From: Simon Davis
Sent: 19 December 2018 17:32
To: Planning Scanning
Subject: FW: BR/273/18/PL The Gables Hotel FAO Miss Sarah Roberts

From: Simon Davis
Sent: 19 December 2018 17:32
To: Critchley Architecture and Design <[REDACTED]>
Subject: BR/273/18/PL The Gables Hotel FAO Miss Sarah Roberts

28 Crescent Road, Bognor Regis, West Sussex, PO21 1QG	Existing Elevations Revisions a) Note/Date/Initial b) c) d)	CAD Critchley Architecture And Design Contact: 02392 474 919 info@caad.online The Old Brewery, 15E South Street, Havant, PO9 1BU		Scale A3 = 1:100 Drawn SAR Date 12/12/17 17085-3010

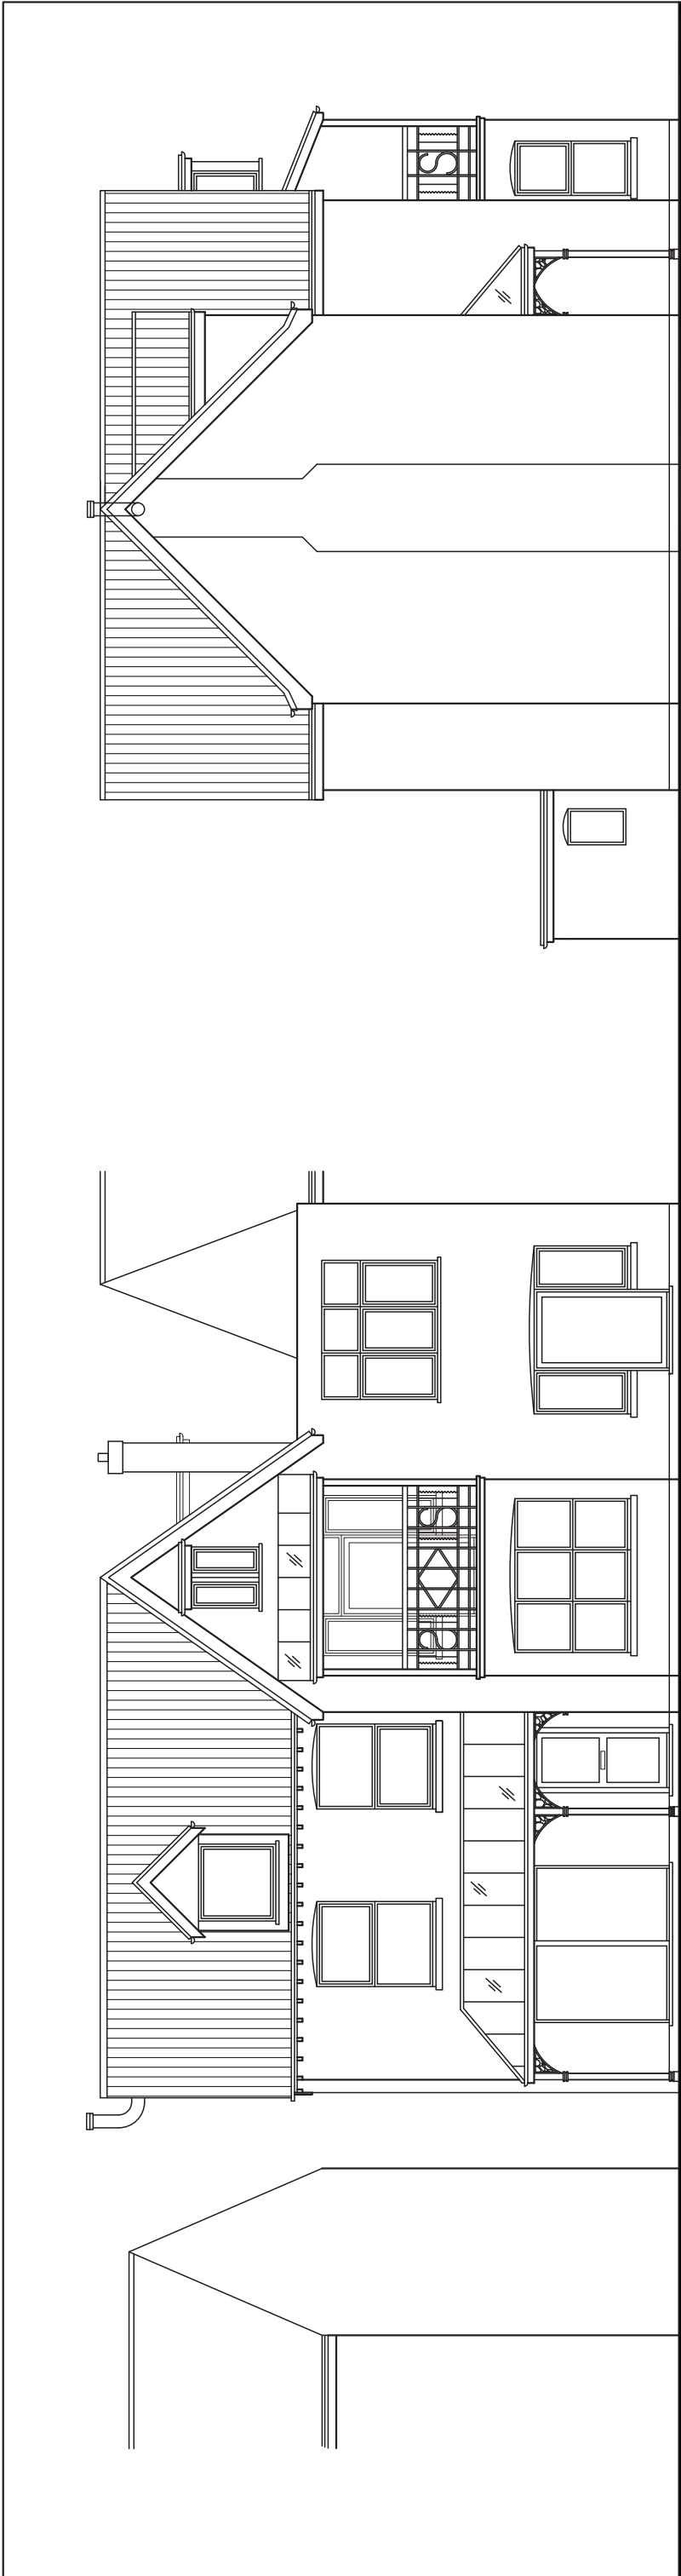
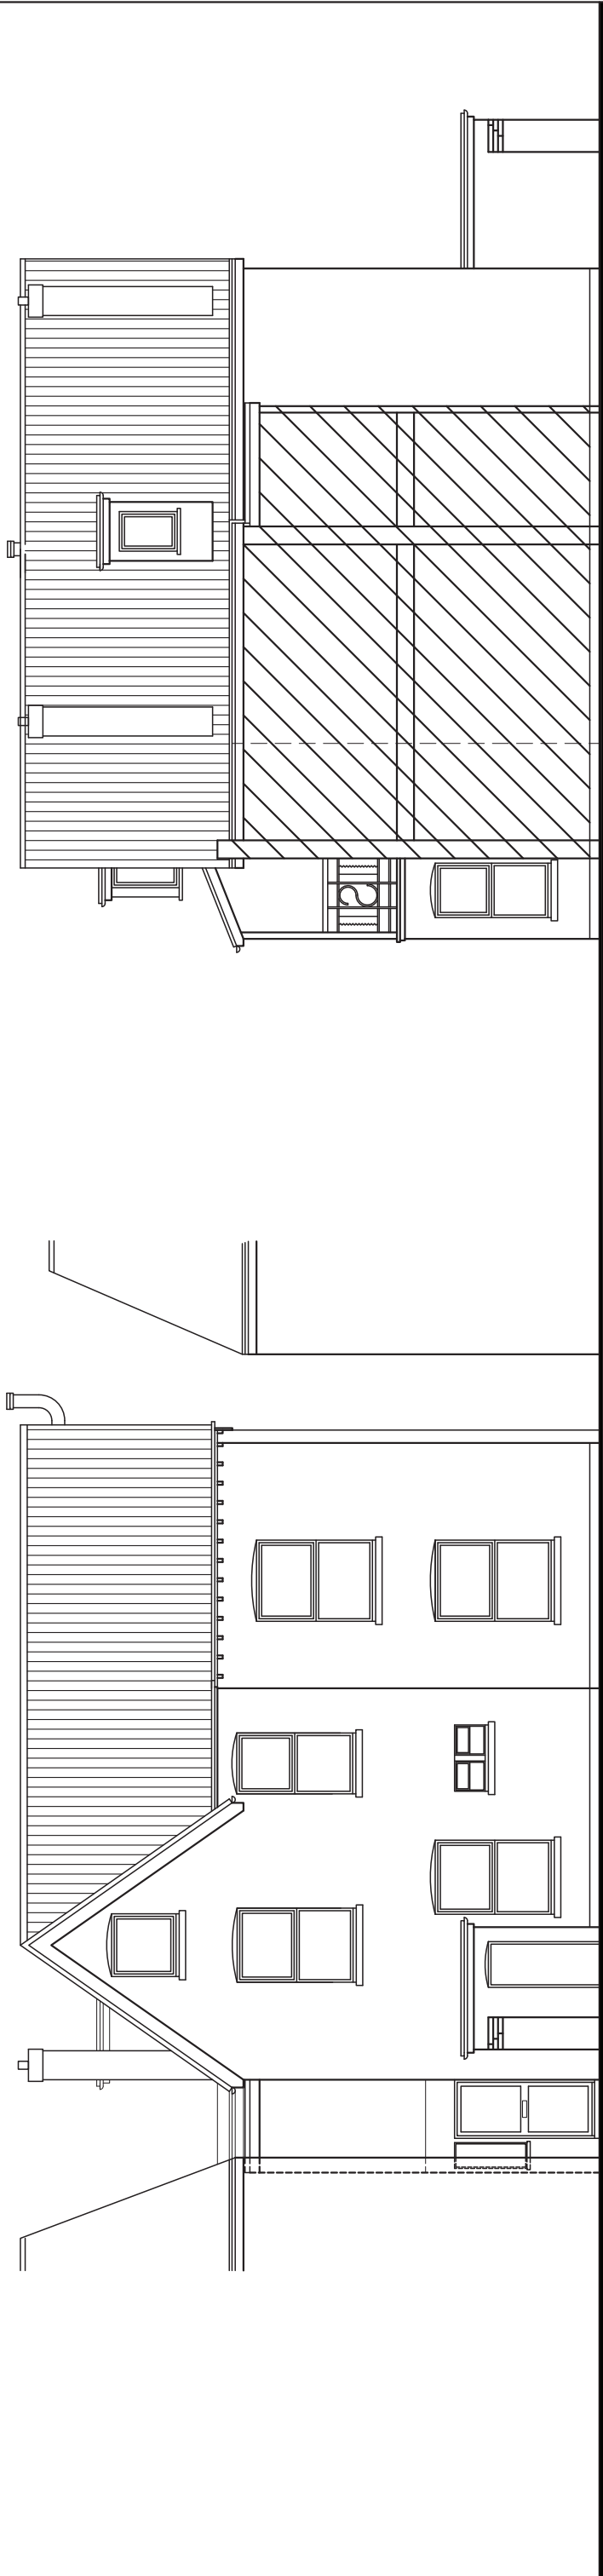
Please can you check over the existing/proposed elevations drawings. The dormer to be enlarged is shown on the south western elevation but by my reckoning the elevation is actually the north western. Can you check and if necessary submit corrected drawings please.
